## 1.0 INTRODUCTION & BACKGROUND

- 1.1 Planning application 21/00559/F was submitted to Cherwell District Council for the conversion of a garage building and erection of a single storey extension, to form a granny annexe on the 18<sup>th</sup> February 2021.
- 1.2 Oxfordshire County Council (OCC) as Local Highway Authority objected to the application on the 13<sup>th</sup> April 2021. OCC's consultation response is based upon the annexe being a new dwelling, however, it is not. The pre-application response of the Planning Officer was clear regarding the status of the proposed development:

2.0 **“UNSAFE PARKING PROVISION”**

06D

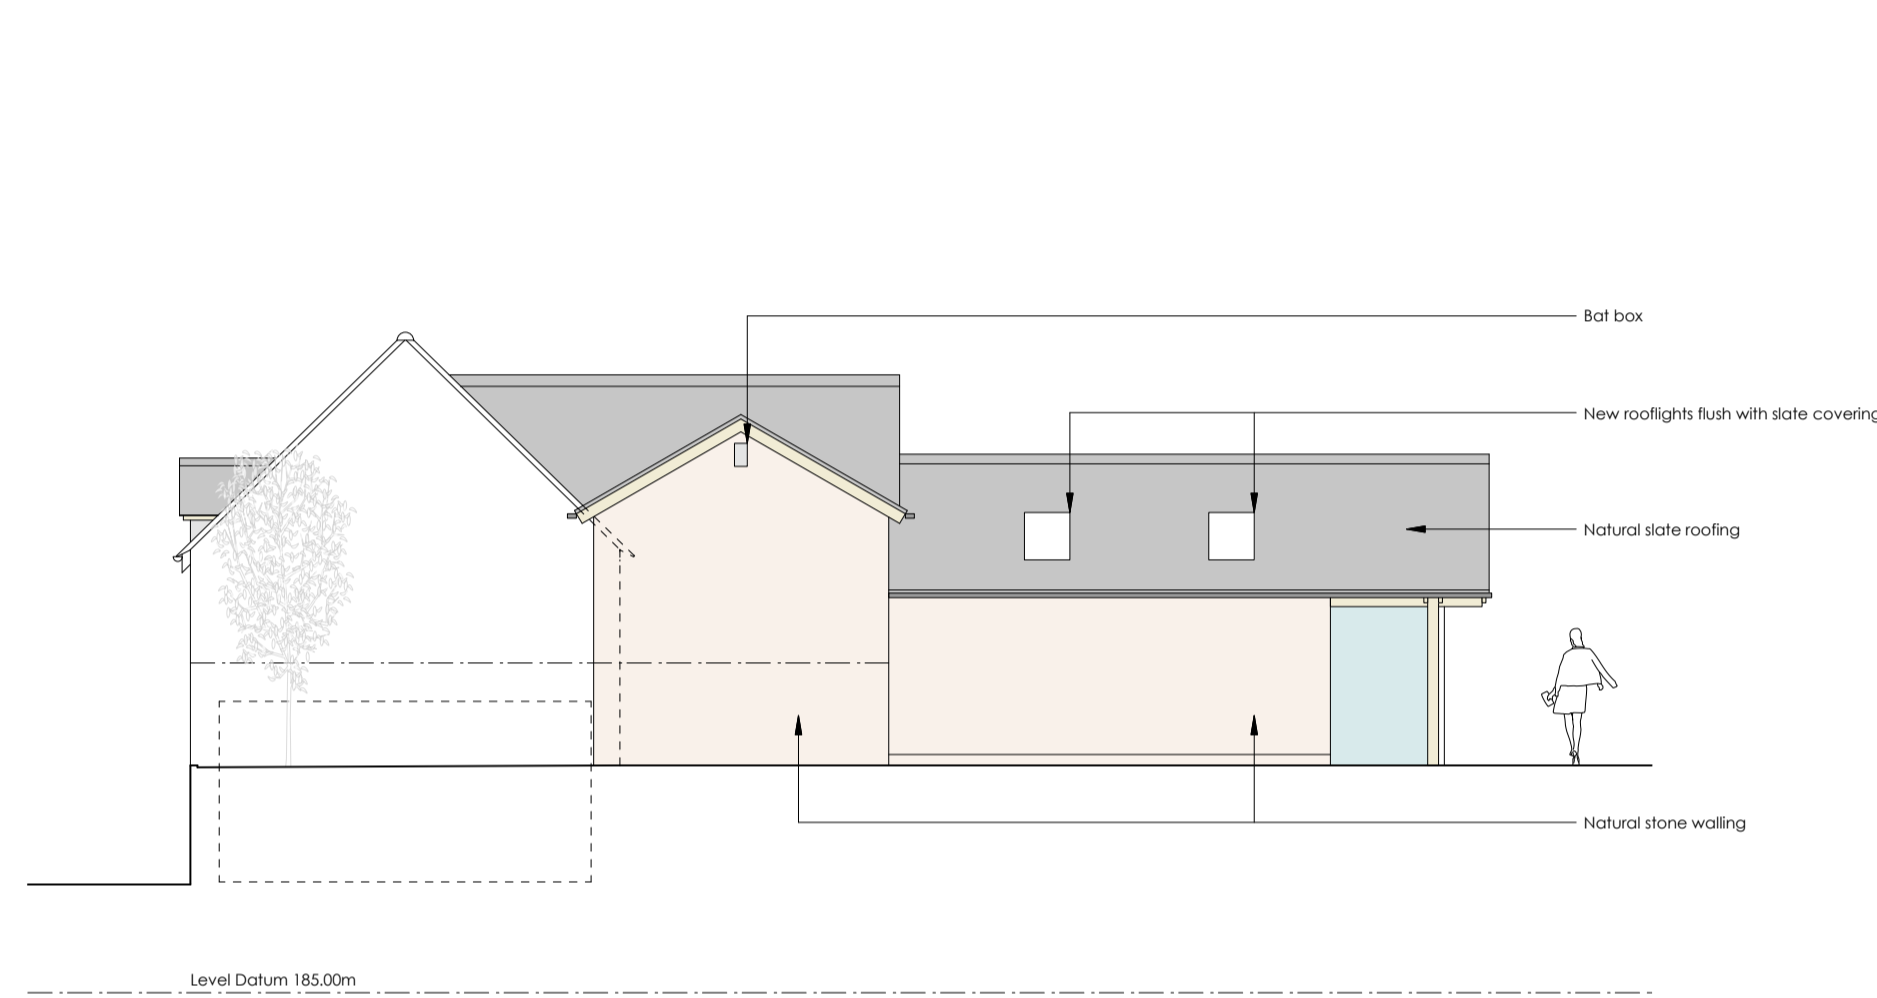
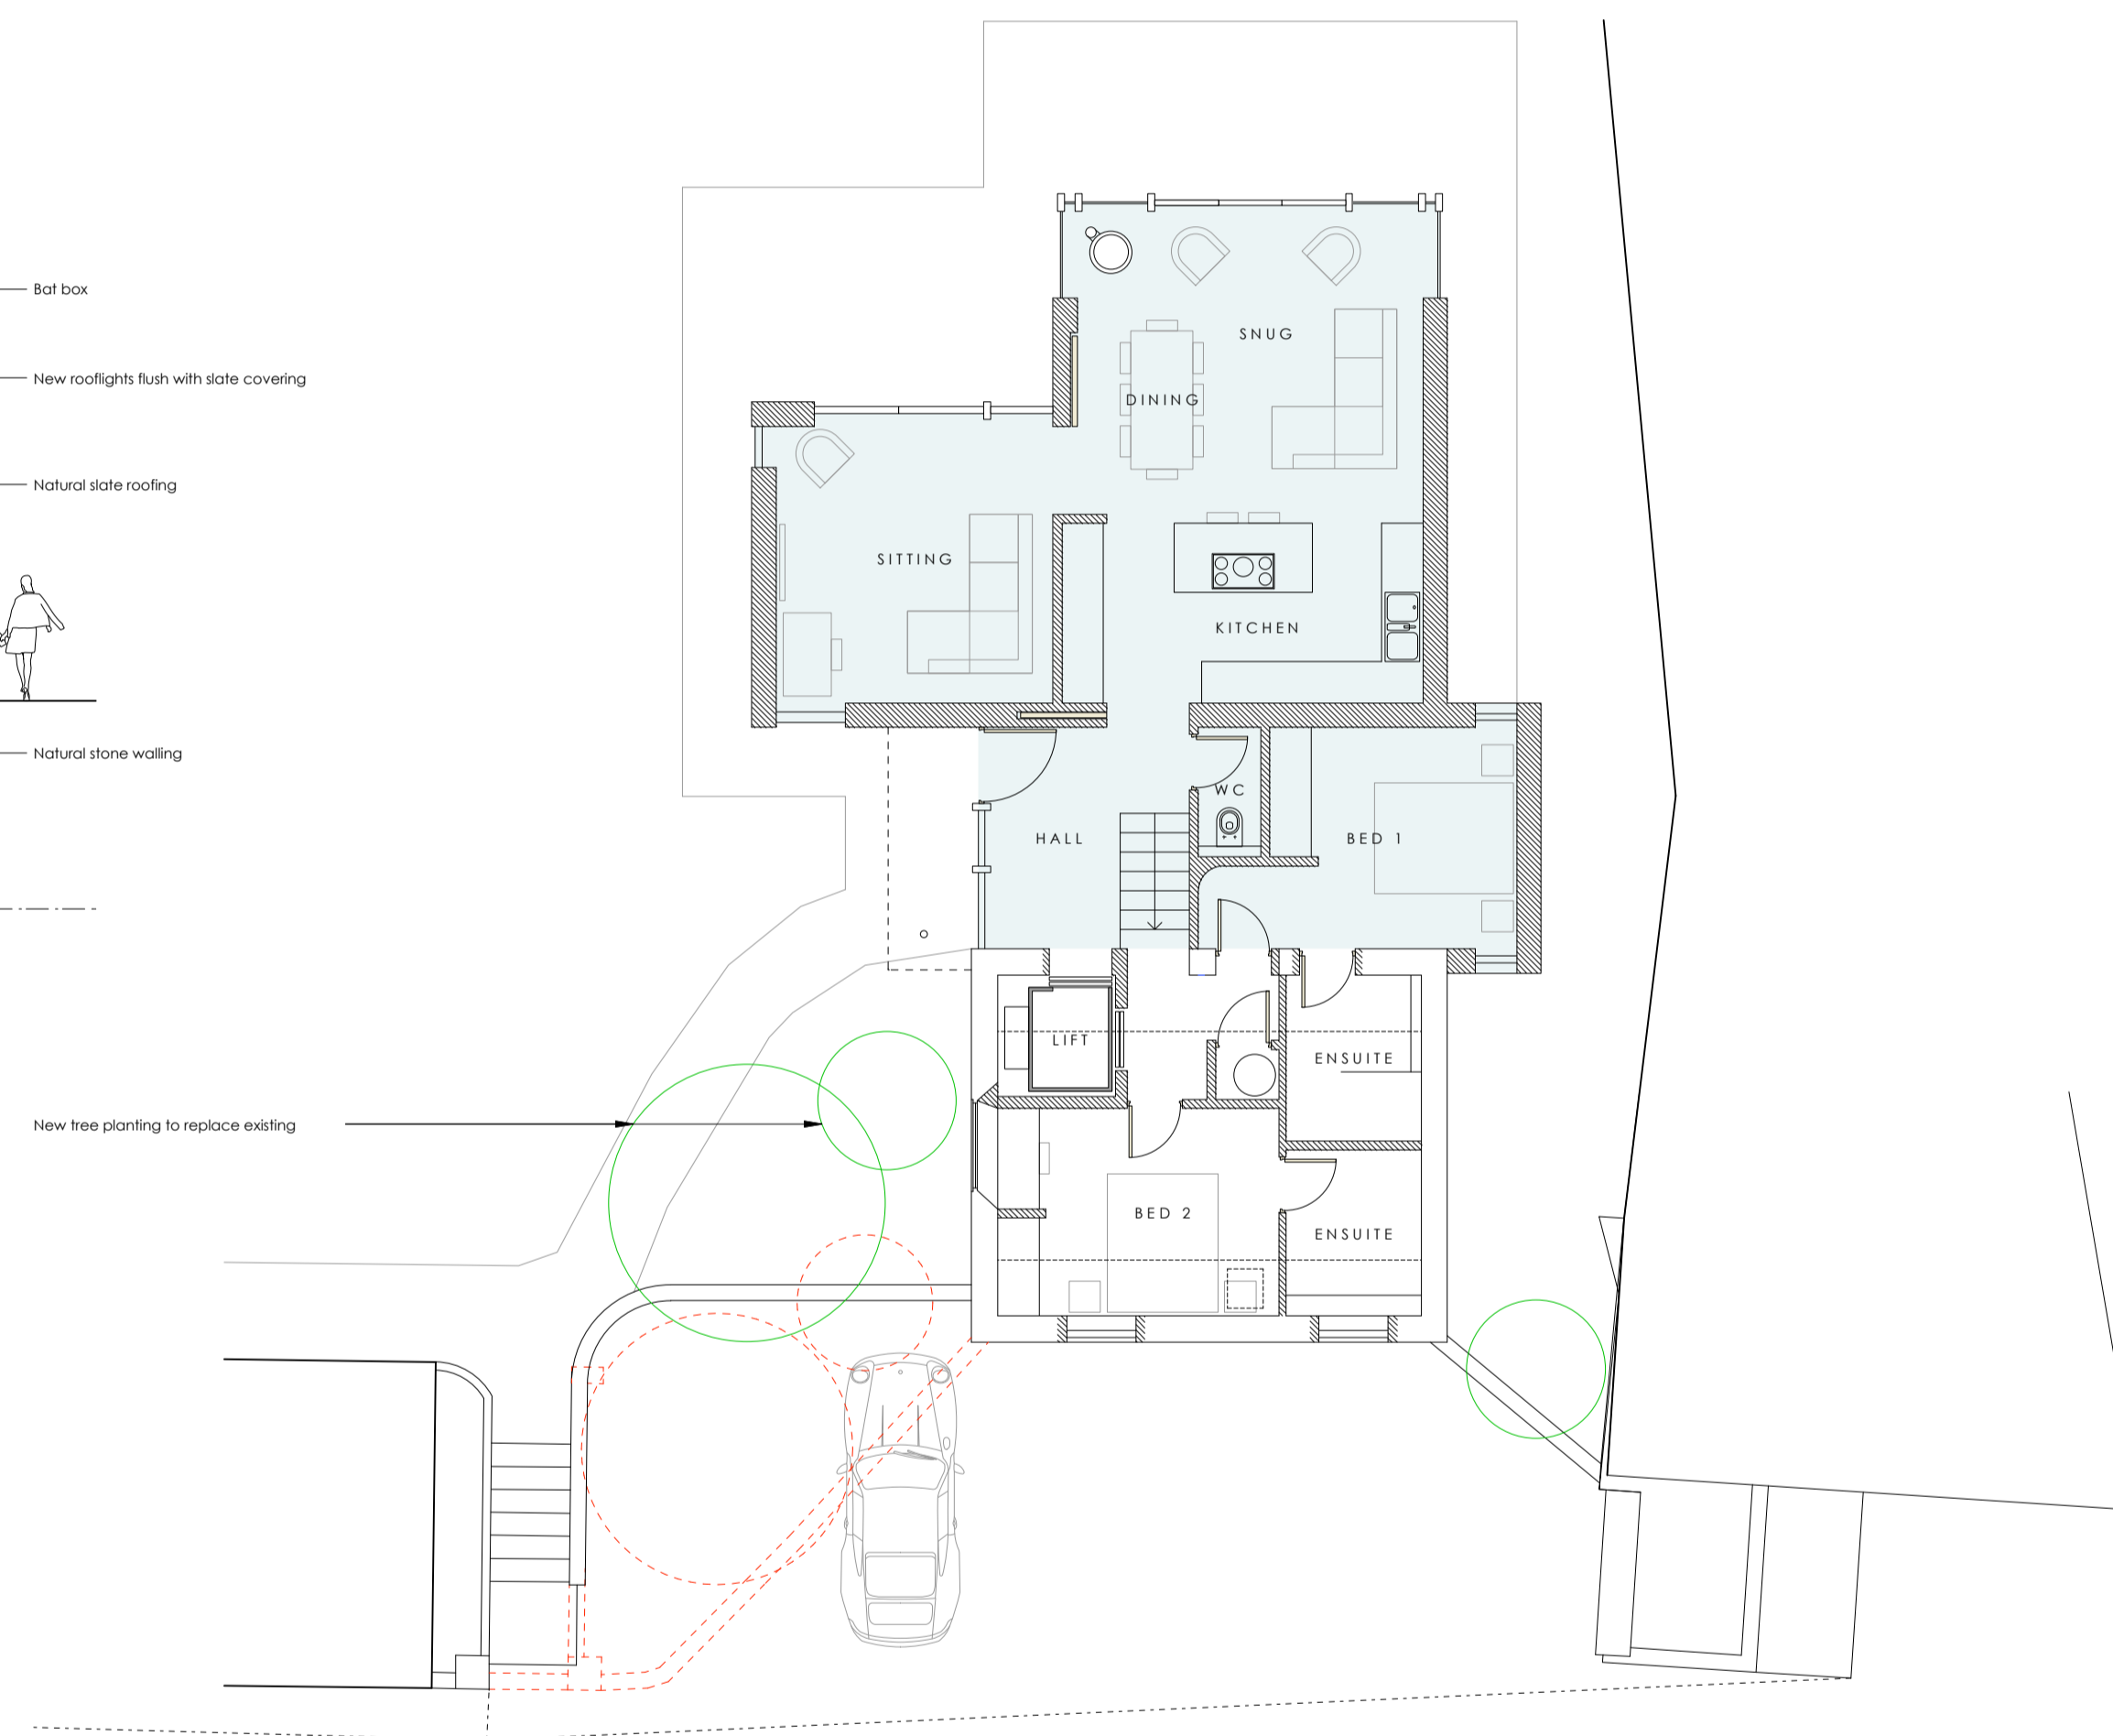
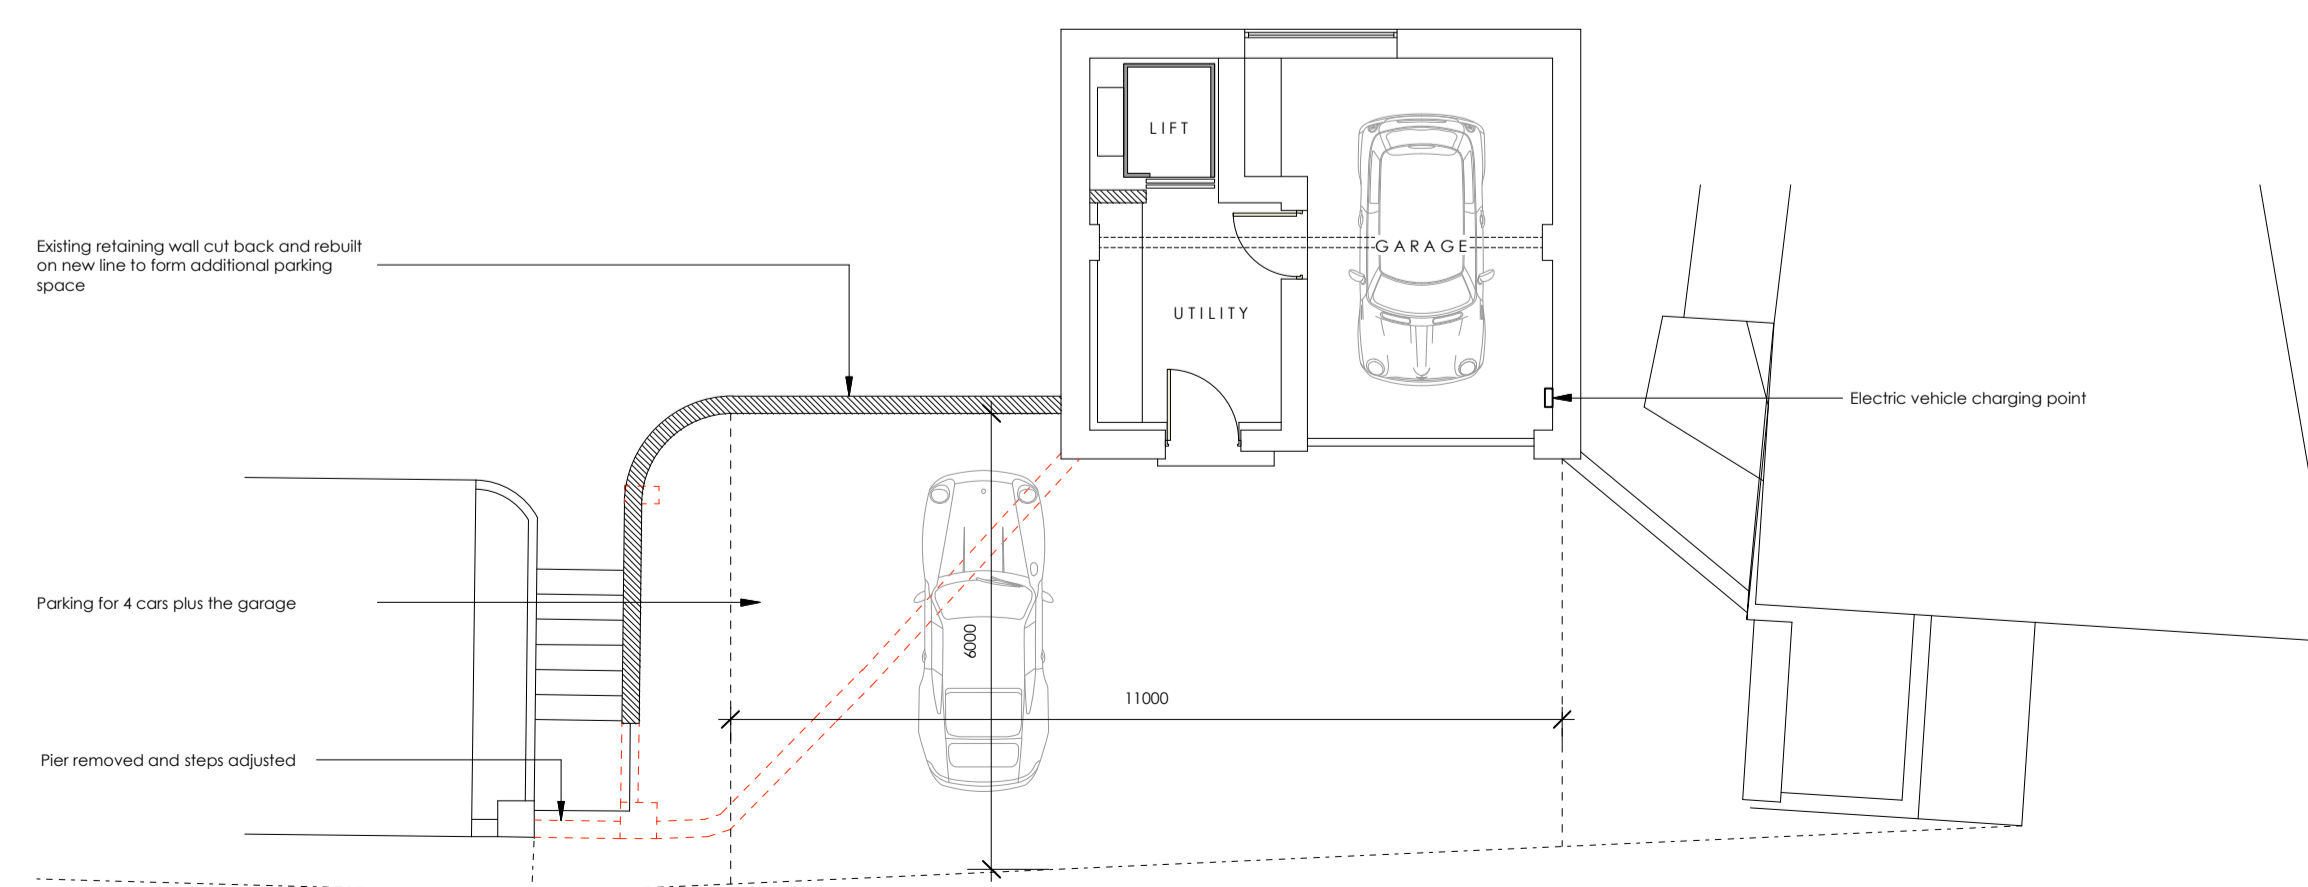
*A sixth parking space has been proposed within the garage accessed from the lower ground floor. However, this space has not been counted as a parking space, as its dimensions fall below the acceptable minimum levels."*

3.5 If necessary and can be justified, whilst the garage currently functions well as a garage, the applicant would be willing to amend this to provide a car port. When compared to OCC's guidance, whilst the garage can be used for parking vehicles, the internal dimensions of 5.1m x 3m falls short of the 6m length required by OCC's guidance. However, a car port only requires an internal dimension of 5m x 2.9m. The development would, therefore, provide 5 spaces.

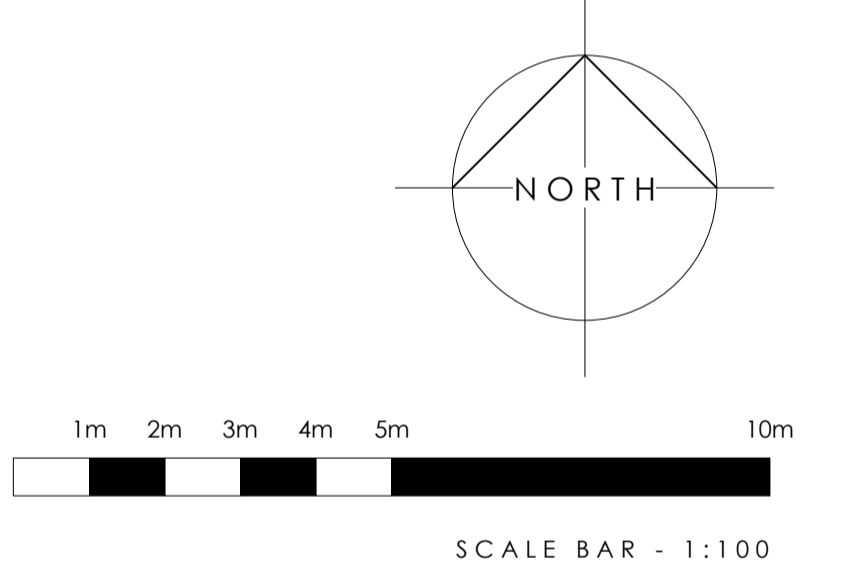
*“...However, I wish to draw the applicant’s attention to the two outer parking spaces as shown on the aforementioned drawings.*

*In order to egress from either of these spaces bounded by the sites boundary walls, this will require the bonnet of the vehicle to project out by at least a meter if not more, prior to the driver having any visibility at all of pedestrians, cyclists or other road users. This can be clearly seen from drawing 07B and the image of a car parked within this space.*

*“Therefore, this area labelled on drawing 07B as ‘existing dedicated parking space for Carters Yard Off Main Street’ is not for the exclusive use of on single dwelling, but instead free to use for the safe parking of any UK road legal. As a result, this parking space cannot be included within the overall parking provision for this dwelling, or the existing or proposed annex on site.*

3.2 As set out in section 2 above the northern most space and as demonstrated on the submitted plans due to the space being pulled further from the northern boundary it is more than reasonable to include this space in the site's provision.

- 4.2 This is accepted. However, as can be seen in the image below the space is within the buttresses of the walls to the house and has been exclusively used by the applicant for many years. Therefore, in reality this space is used by the applicant or their visitors.
